**From:** [NectonSubstationAction Messenger](#)  
**To:** [Norfolk Boreas](#)  
**Subject:** Deadline 4 False Ridgelines  
**Date:** 23 January 2020 14:39:40

At the Specific Hearing on 21st January 2019 yet again the applicant was insisting, on record, that no-one in Necton or Ivy Todd will see the substations. When one considers the massive scale of the buildings, this seems very unlikely to be true, and indeed, living here, we know it is not.

Title:	Scenario 1 Viewpoint 2: Lodge Lane South
--------	--

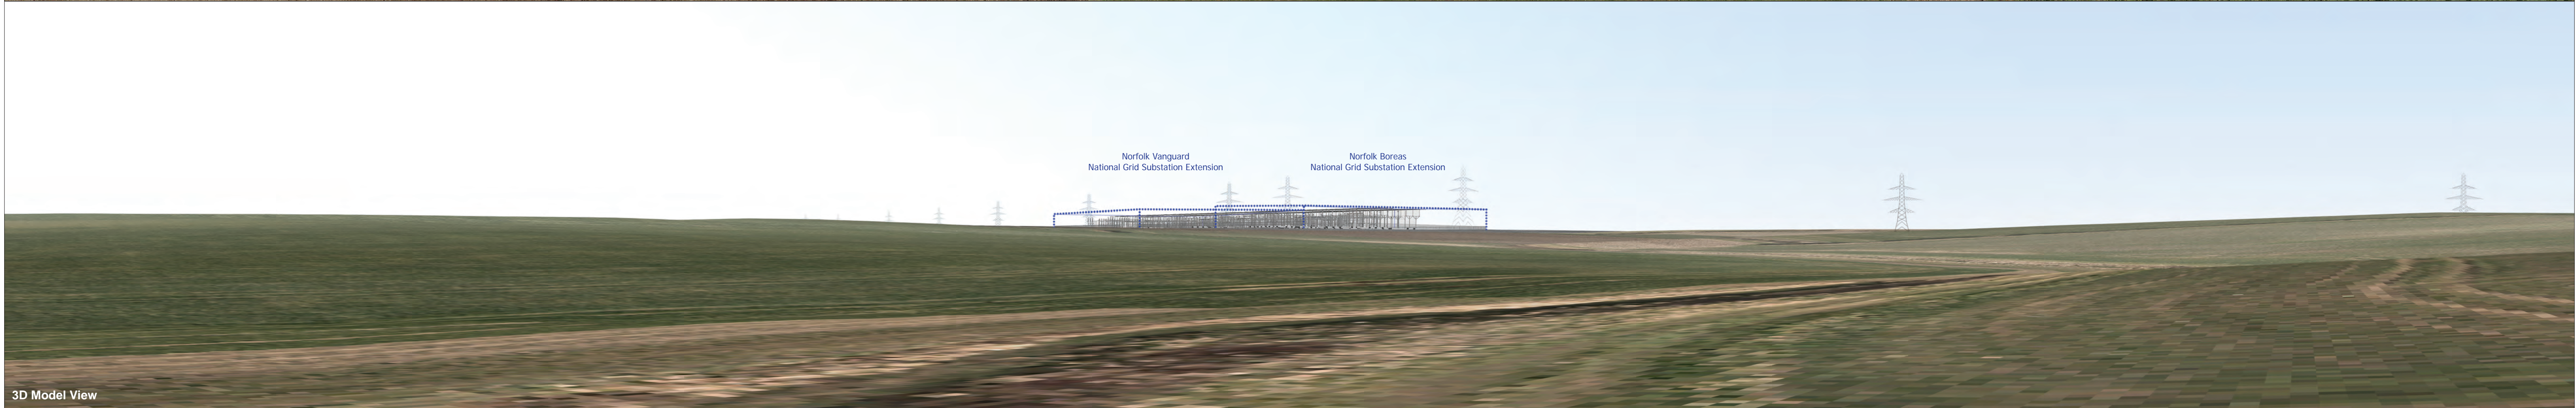
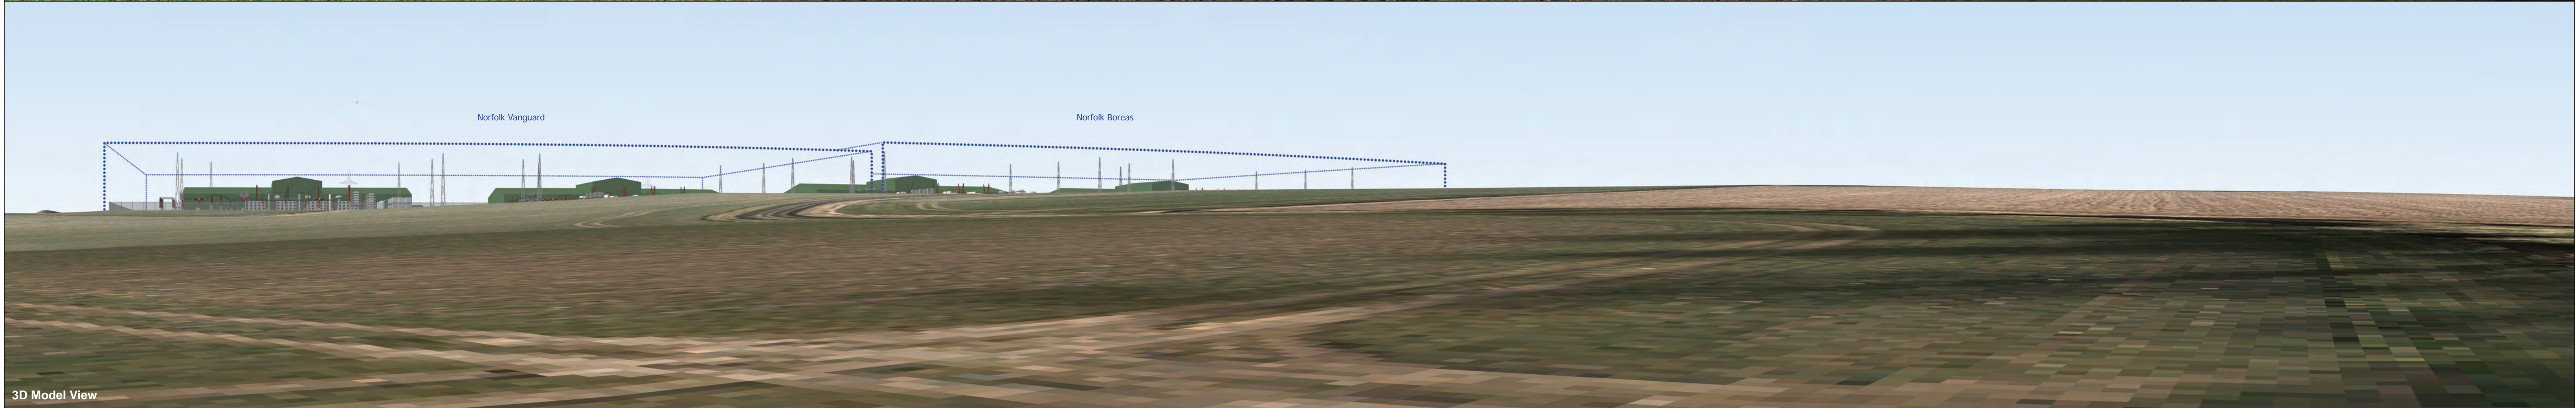
Yet again there seems to be serious flaws in the applicant's software and reasoning, causing discrepancies in both their photomontages and even more seriously in their ideas for mitigation. This is a huge danger with a project that is mostly decided by desk-based research only. It is terribly frightening that the applicant has been so unwilling to listen to local knowledge about this or other factors such as flooding. To dismiss the concerns of people who have lived up to 80 years in the area, must be wrong, and indeed foolish.

Mr Colin King's research has shown to our satisfaction that "the OS 5m DTM software used has an accuracy of +/- 2.5m rural, and less accurate where trees and buildings cover the terrain. The aforementioned mature woodland associated with Lodge Farm, has the capacity to cause a ridgeline great enough to cause the effect we are seeing at viewpoints 2 and 3 Lodge Lane."

Which means that the software is not only giving wrong heights for actual land, but also reading hedges, not as hedges but as land ridges. This would explain the fact that when they showed people the views from their own properties using their postcodes, no hedges appeared on the screen between the properties and the substations, and the ground was featureless as regards hedgerows.

At the time we were told that the software did not recognise trees and hedges, so they were omitted, when in fact the truth appears to be that it was showing them as changes in land height and as ridgelines. It is on these non-existent ridgelines that the applicant plans to plant trees, when in fact they could well be 'invisible' or non-recognised hedges, not ridges, which of course they cannot plant on top of.
